Application number: 2021/92462	
What is the application for?:	Outline application for erection of detached dwelling
Address of the site or building:	rear of, 1091, Manchester Road, Linthwaite, Huddersfield, HD7 5LS
Postcode:	HD1 4QT

Type of comment: An objection	
Do you wish your comments to be published on the website anonymously?	No

STATUS			PROVISIONAL		
PROJECT			LAND OFF 1091 MANCHESTER ROAD		
TITLE			PROPOSED		
CLIENT			P.WHITING		
DRAWN BY	CHECKED BY	DATE			
Author	Checker	12.05.2021			
SCALE (@ A1)		PROJECT NUMBER			
As indicated		HD.20.33			
DRAWING NUMBER				REV	
HD.20.33.01

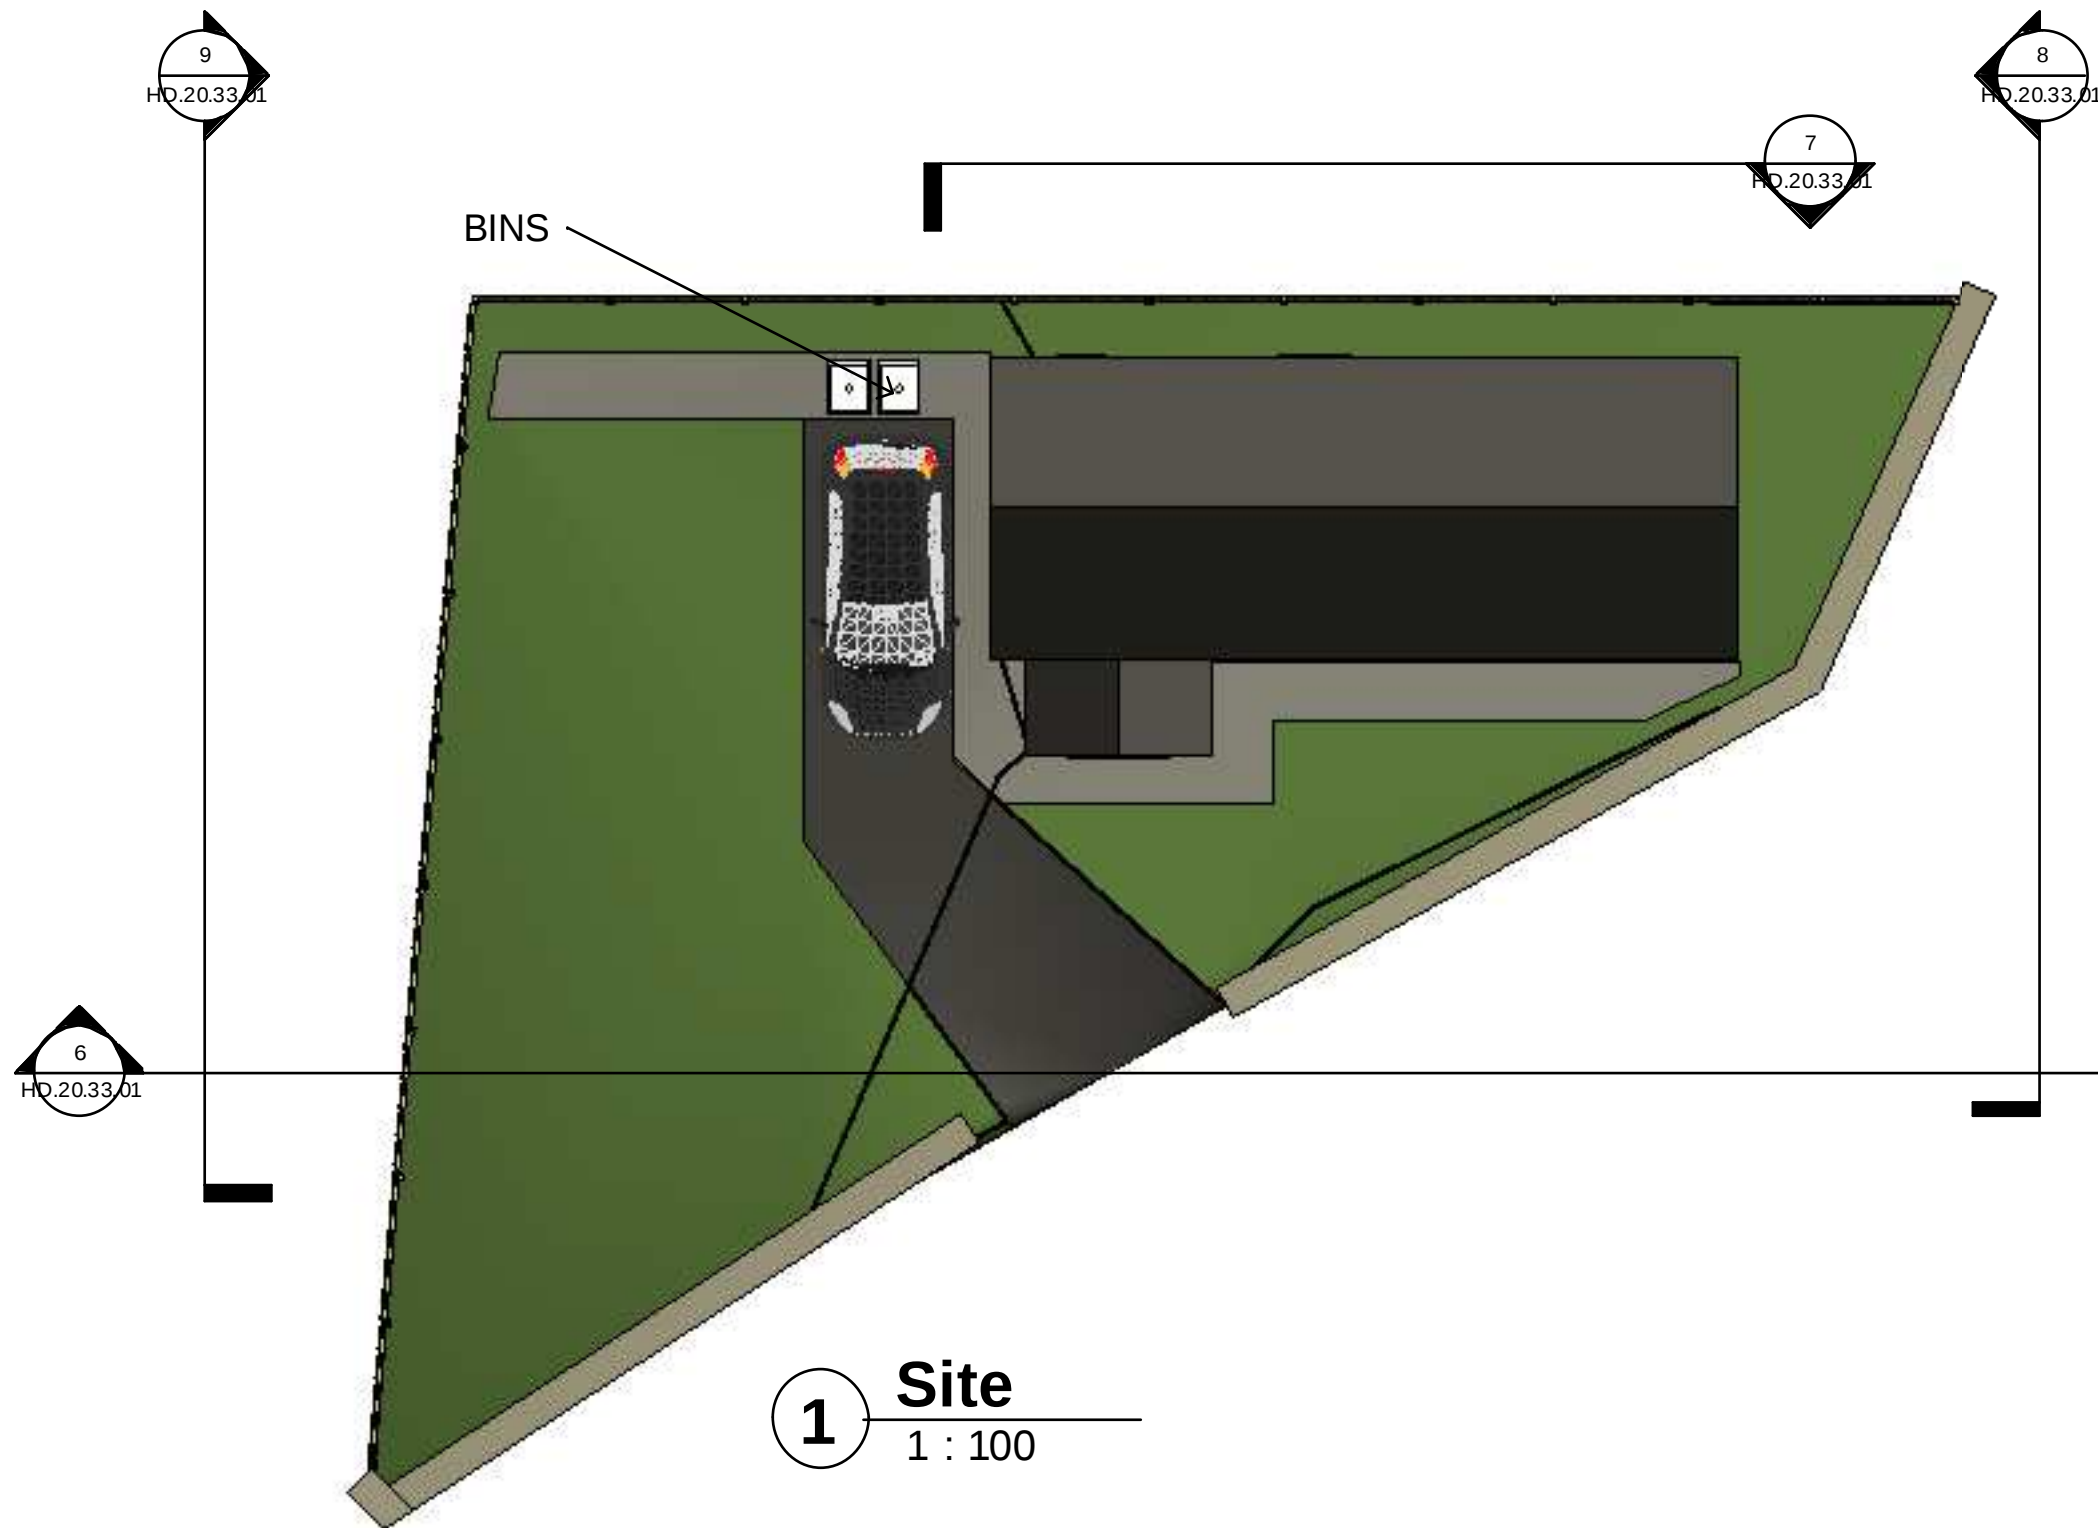
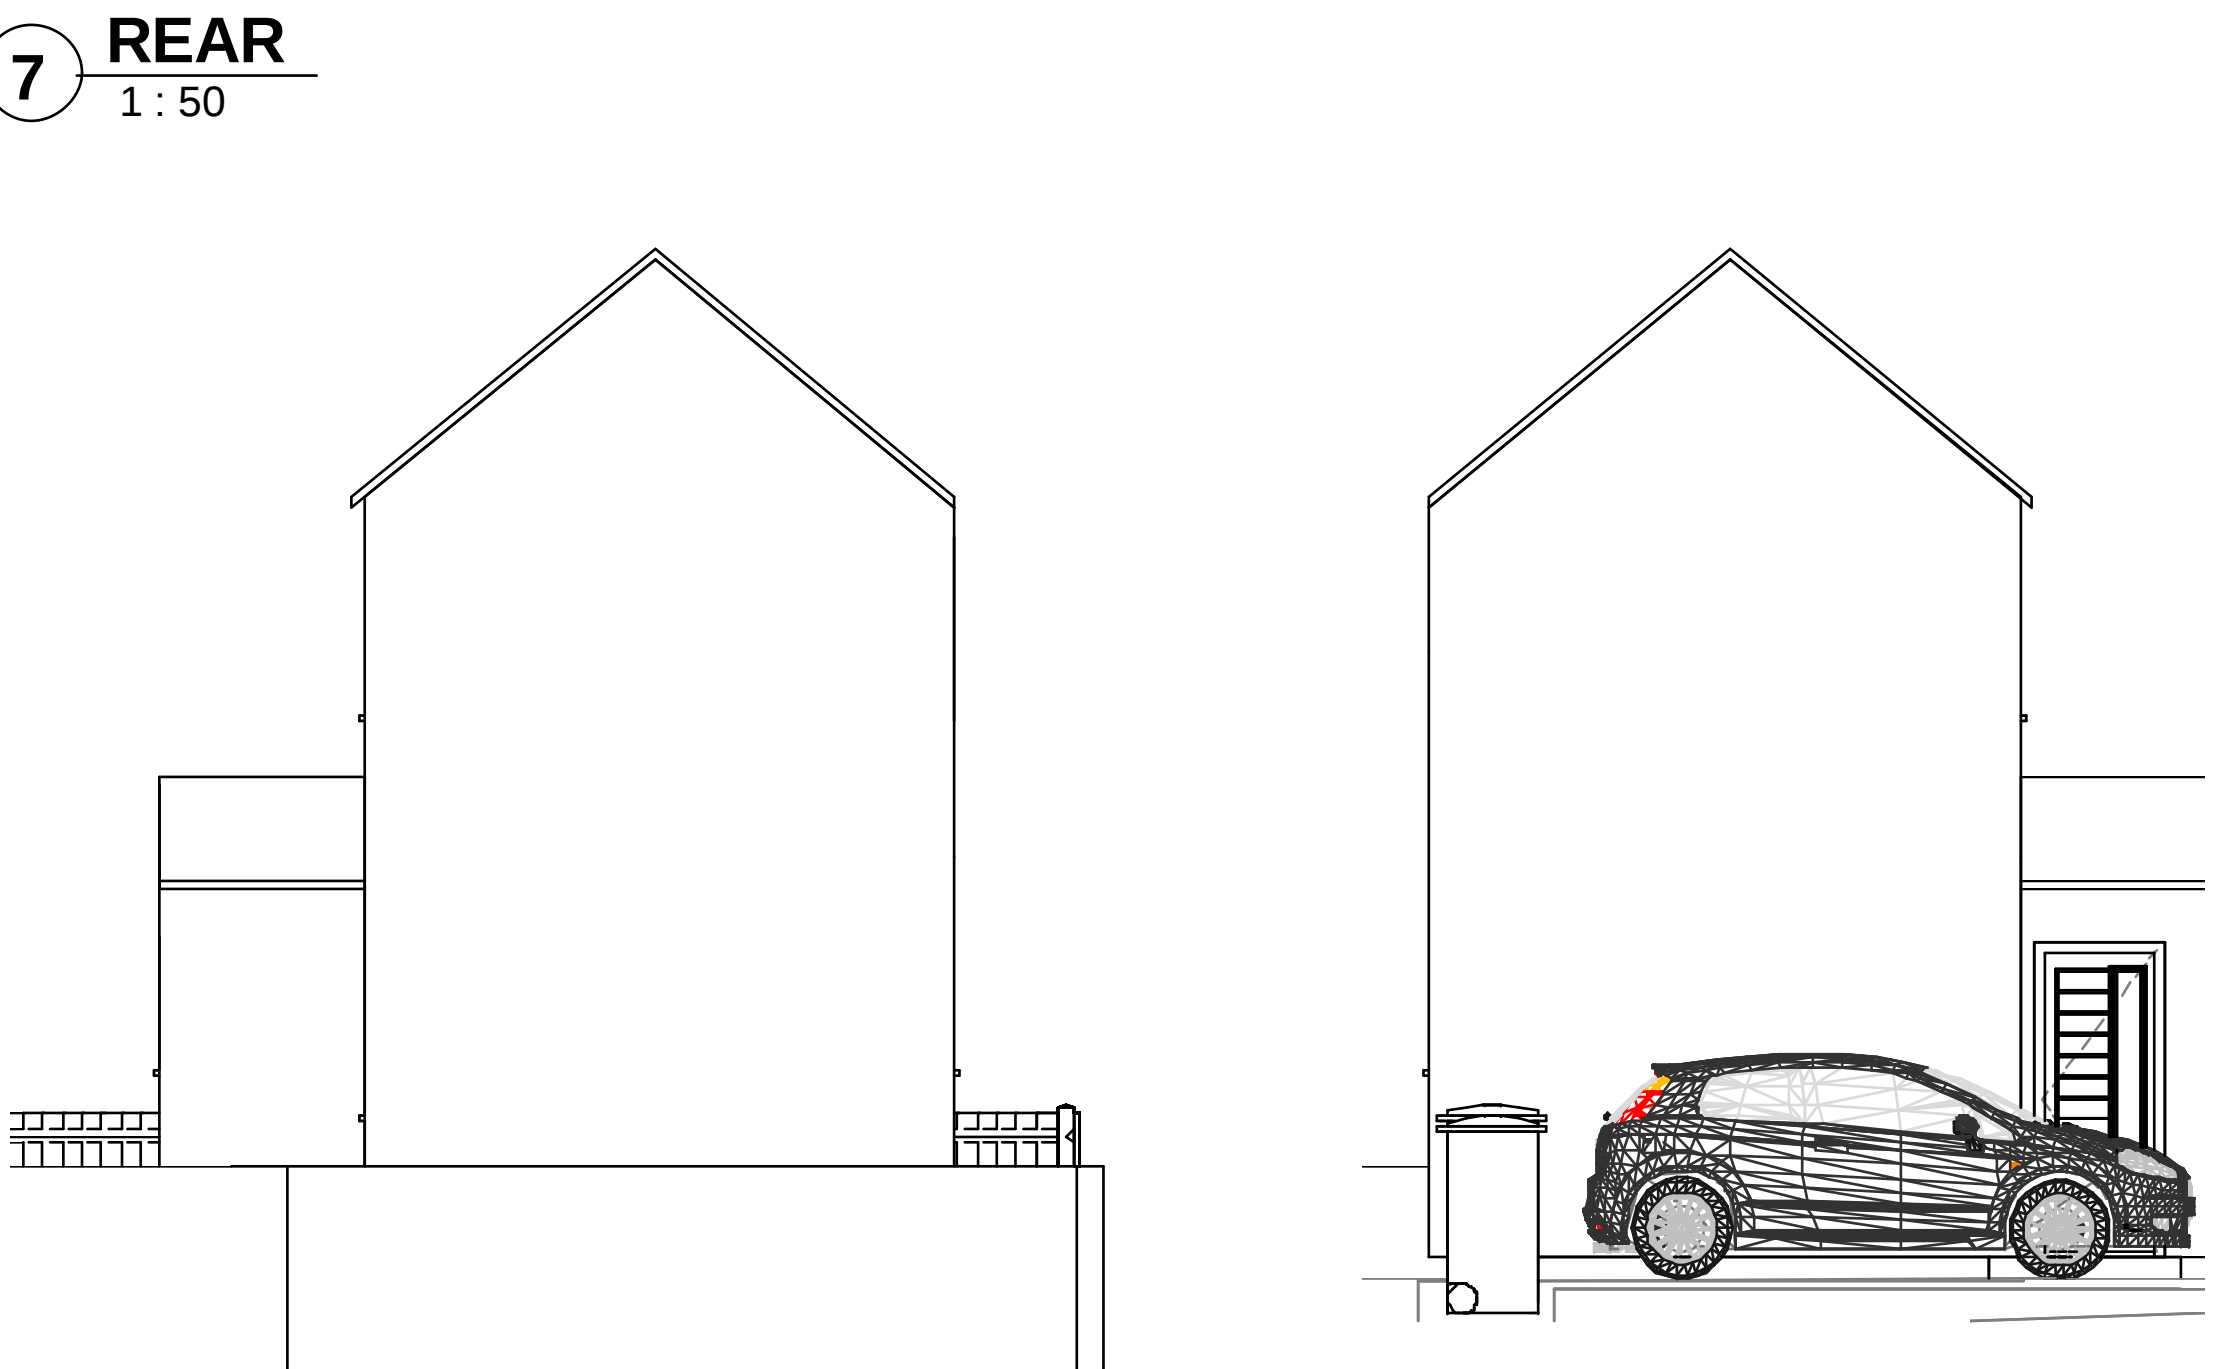
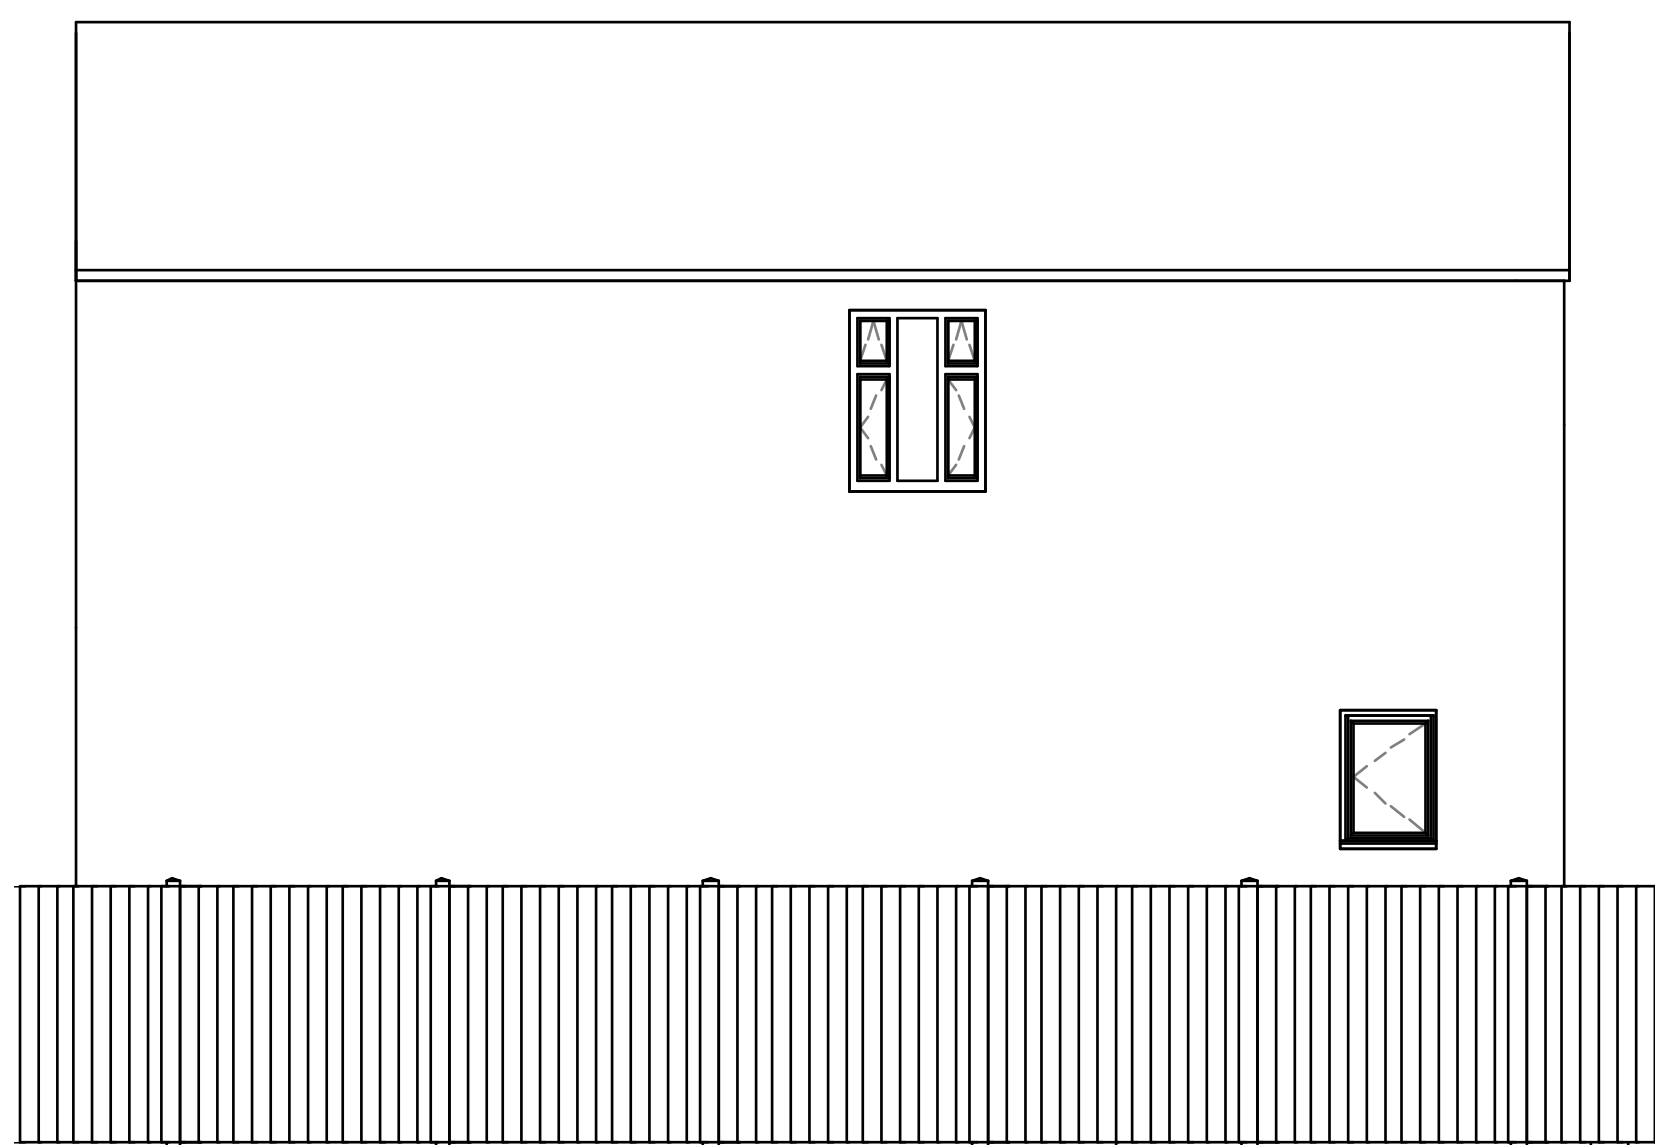
The proposed development, would largely be built of artificial building materials, it would not fit in with the other properties in the Fold, as they are built of Yorkshire stone. It would be out of character in the setting.

The house and the flat pictured, in the heritage statement, (which are both owned by the proposer), the tenants of these properties and their neighbors, would have no privacy and would be overshadowed by the dwelling.
